**Our Case Number:** ABP-318704-23

**Re:** 10 year development of 9 Wind Turbines and associated infrastructure  
at Borrisbeg and adjacent townlands, near Templemore town in Co. Tipperary  
(<https://borrisbegplanning.com>)

Planning Ref. ABP-318704-23

PROJECT TITLE: Borrisbeg Renewable Energy Development		
DRAWING TITLE: Proposed Access Junction B		
PROJECT No.: 220310	DRAWING No.: 220310 - 38	SCALE: As Shown @ A3
DRAWN BY: GO	CHECKED BY: KD	DATE: 11.12.2023
		REVISION: P01

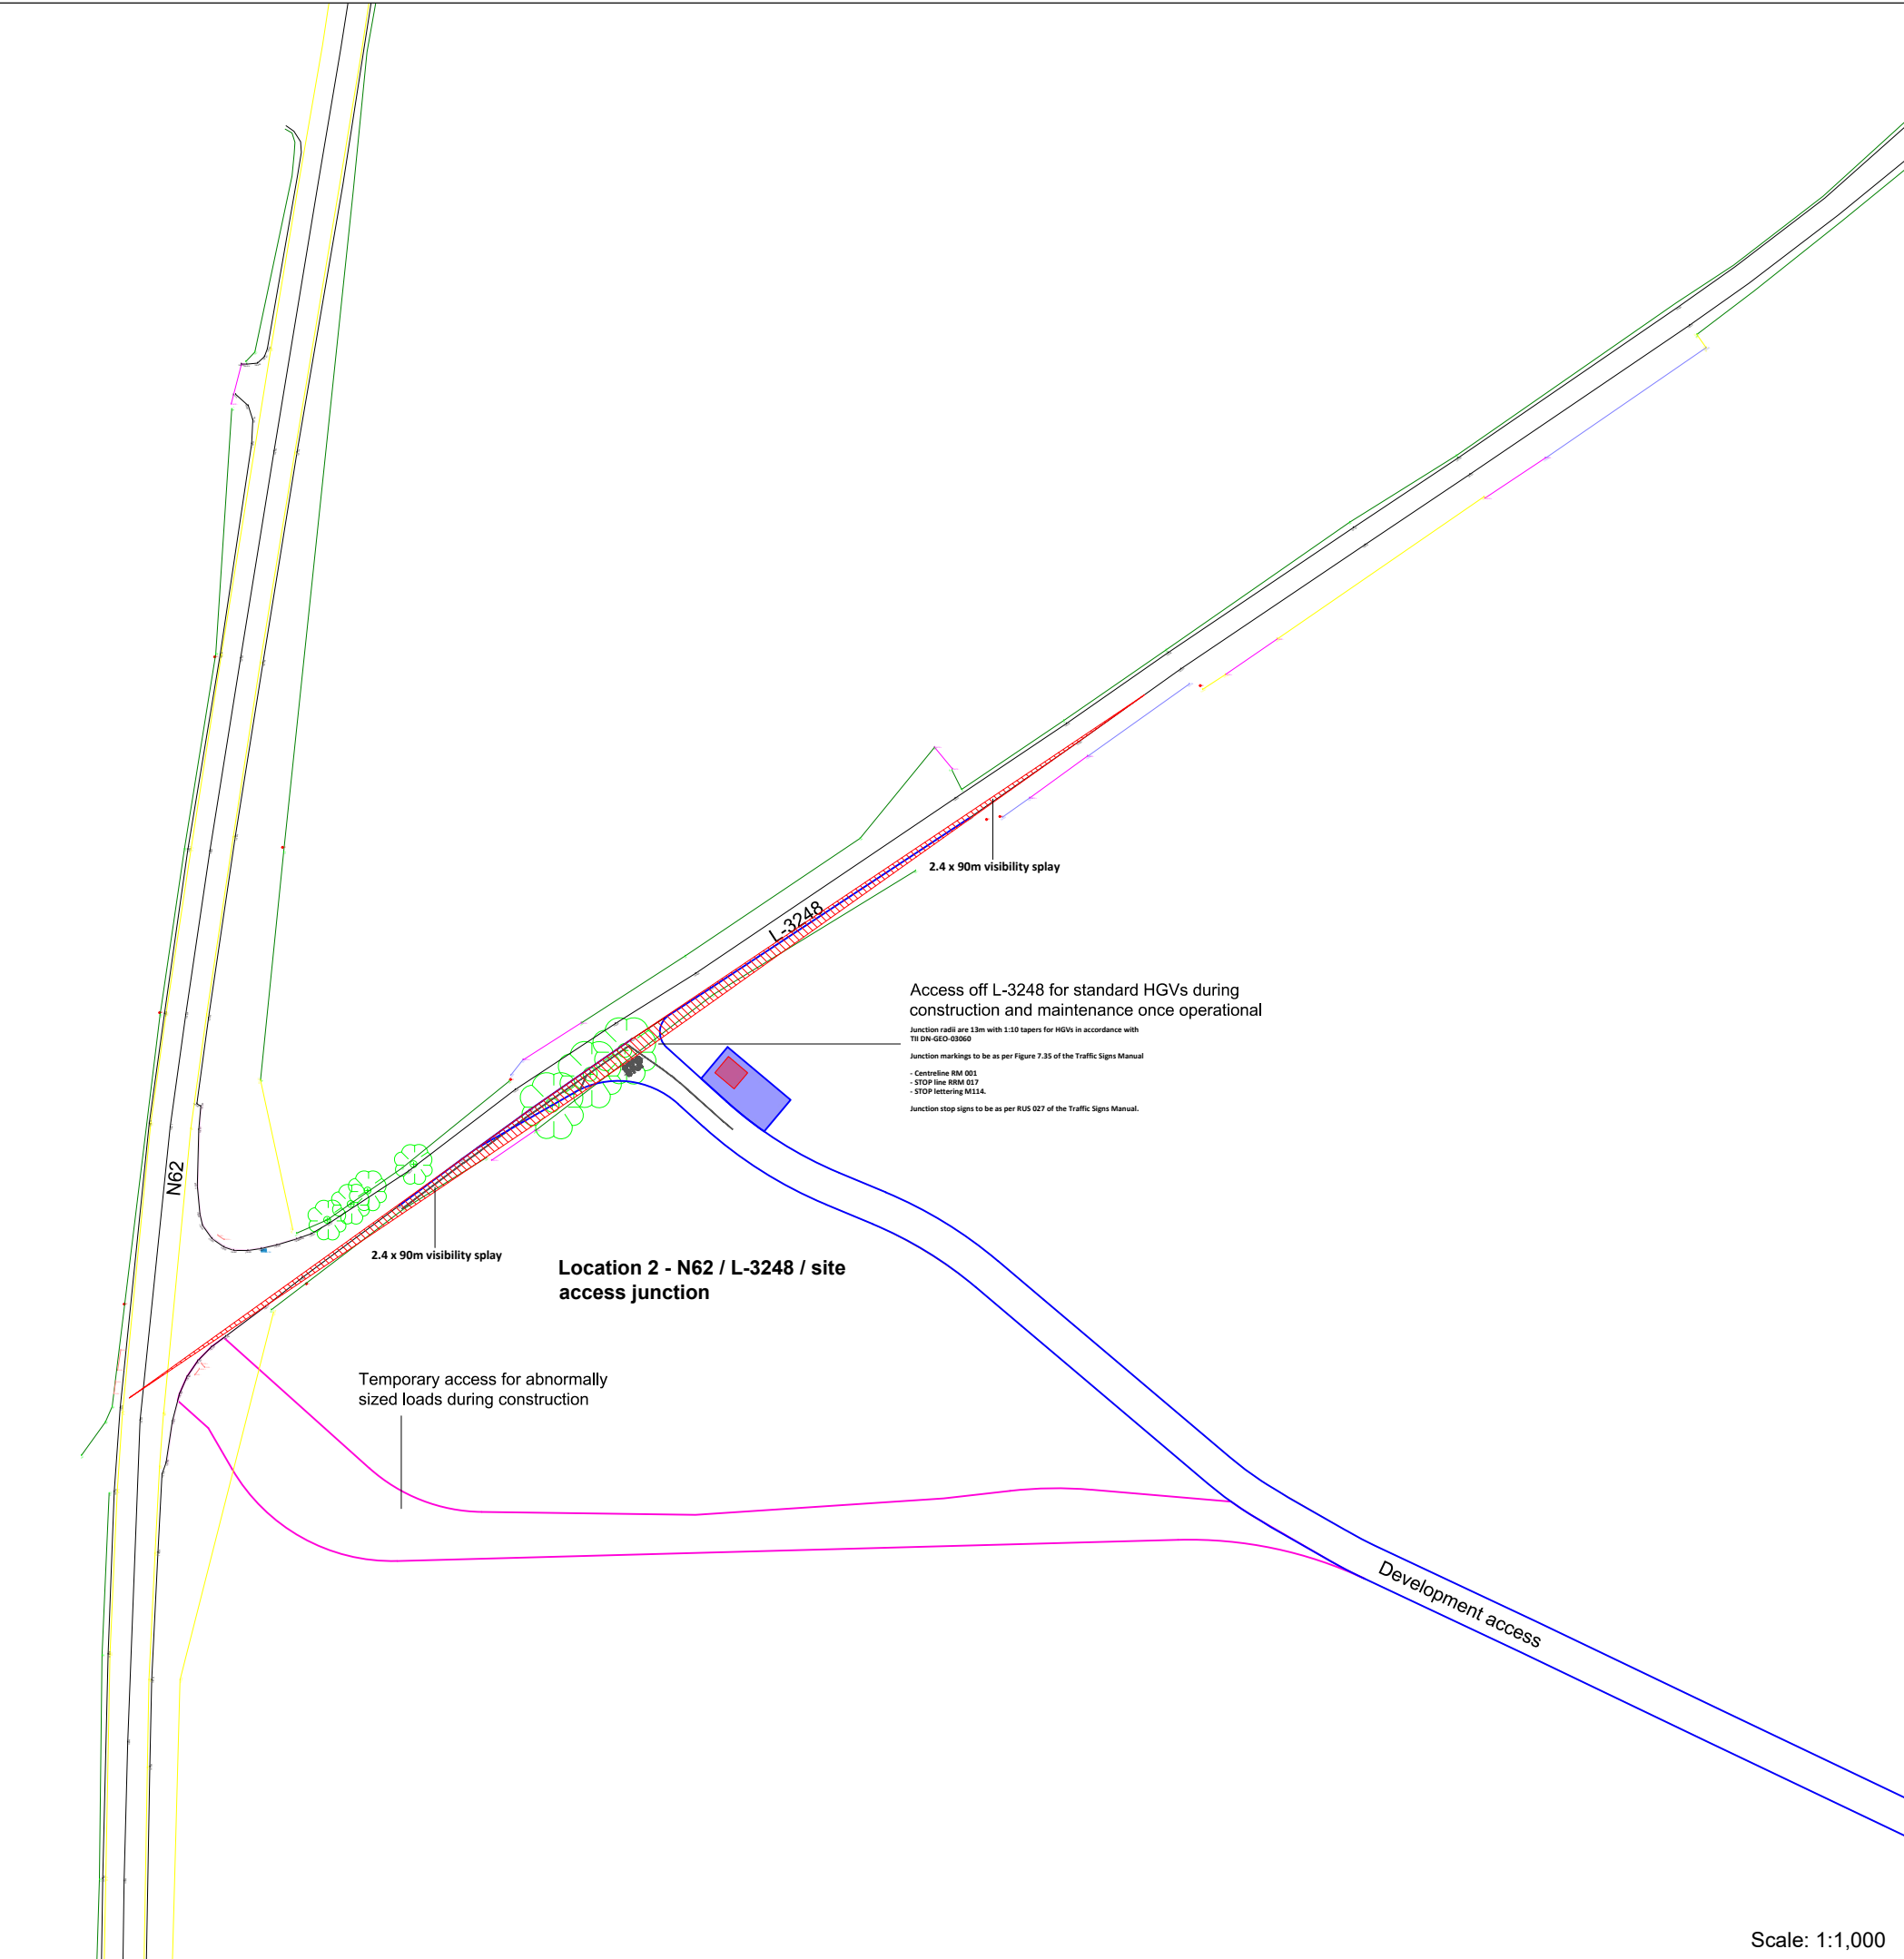
1. The intersection of my road with the main Roscrea to Templemore Road **N62** is still dangerous in my opinion in its current structure despite Tipperary County Council widening both sides of the junction some years ago. There is a hidden dip about 100 metres from the junction towards Roscrea; cars drive at excess speed; there are no warning signs of a relatively hidden junction. When you drive out on to the N62 towards Templemore before you know it there is a car right on your tail.

It is where both these roads join together that the proposed construction site entrance is being inserted. Trucks bringing hard core and road surfacing in addition to foundation material for the turbines will be delivered via this construction site entrance.

Ginormous sections of turbines requiring Garda escort are proposed to be delivered at this already compromised junction in the middle of the night. At the RIGHT ANGLE of the joining roads. Blue lights flashing as if it were an emergency zone. Possibly even warning siren alarms.

Shouldn't this be explored more if it was originally deemed the best site for the entrance? The road is straight at this junction with clear visibility And is much safer in my view.

1. As the owner of the land where it is proposed to construct the new entrance road has plenty of road frontage the entrance could be placed further down the main road away from residential houses.
